6 October 2021

COCKLE BAY PARK [SSD 7684] - DESIGN INTEGRITY PANEL SUMMARY

W2 West Elevation
SCALE: 1 : 250

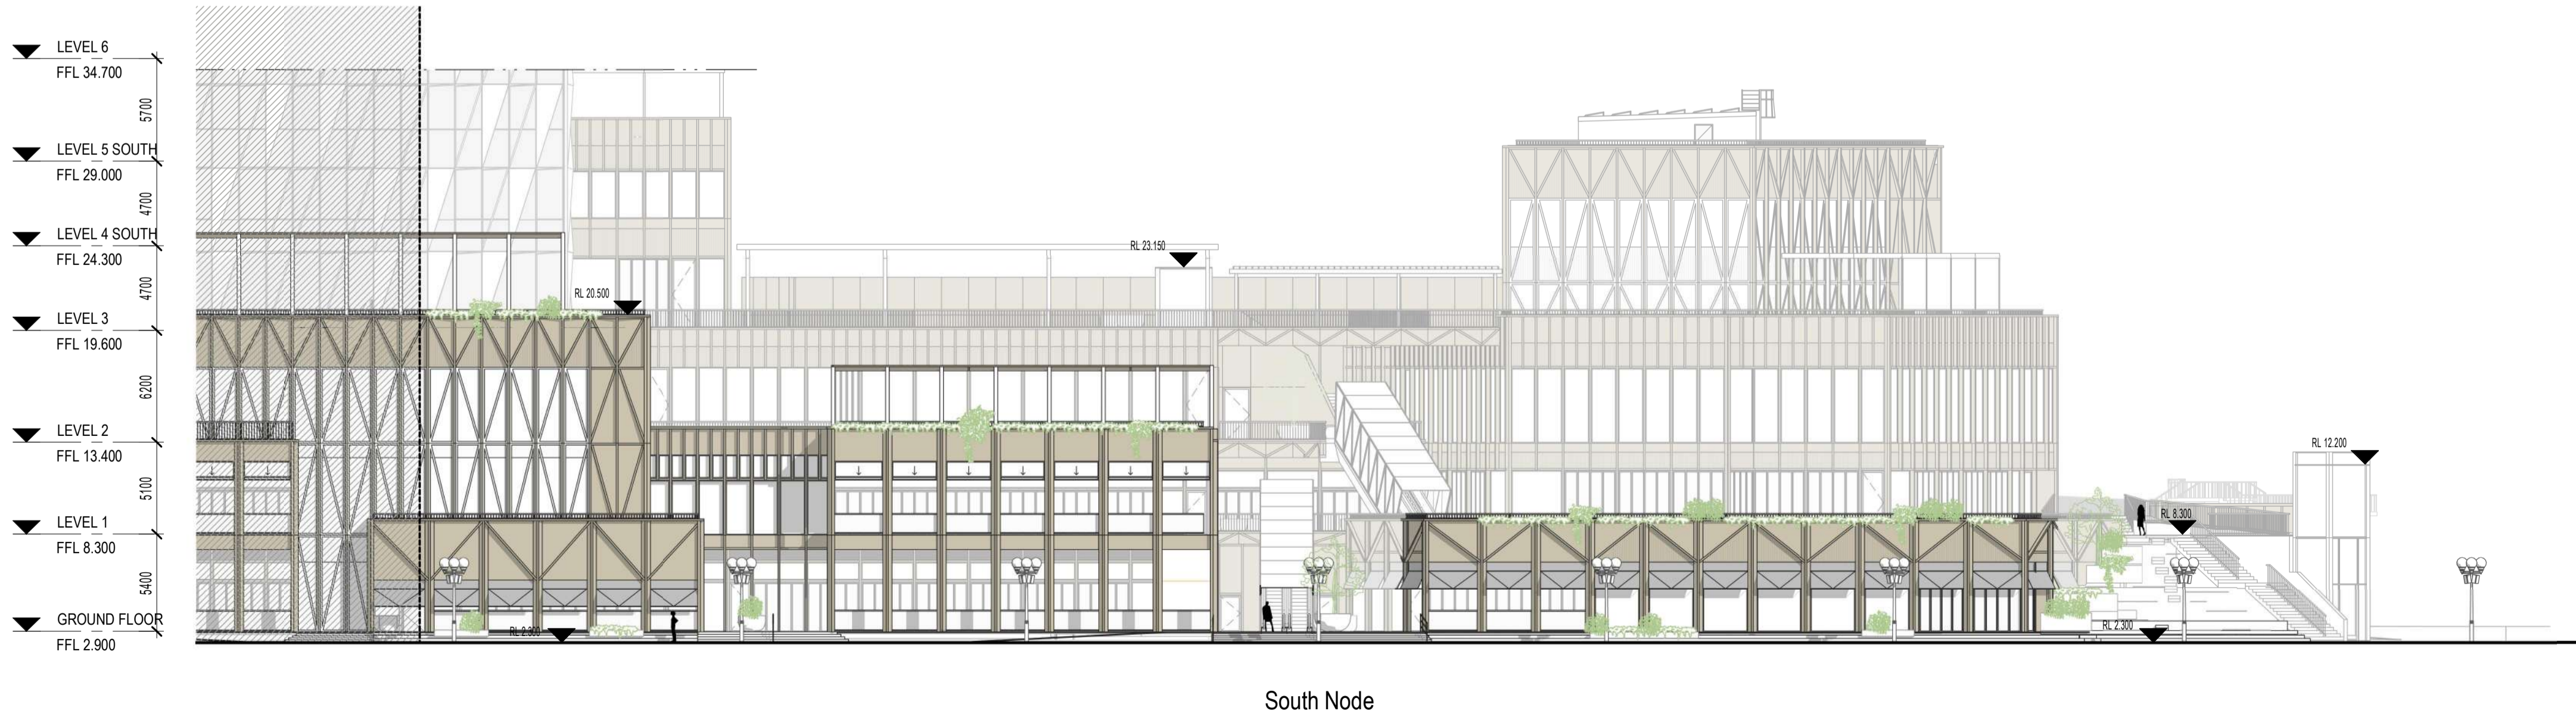
Design element	DIP Feedback
Darling Harbour frontage – southern retail podium	<p>Refer to DIP Feedback 7 & 8</p> <ul style="list-style-type: none"> ▪ Whilst the Panel supports the consolidation of the southern parkland, a number of factors have contributed to the Darling Harbour southern podium façade having a more conventional podium character through the long horizontal balustrades and consistent parapet heights, as illustrated in the below excerpts:
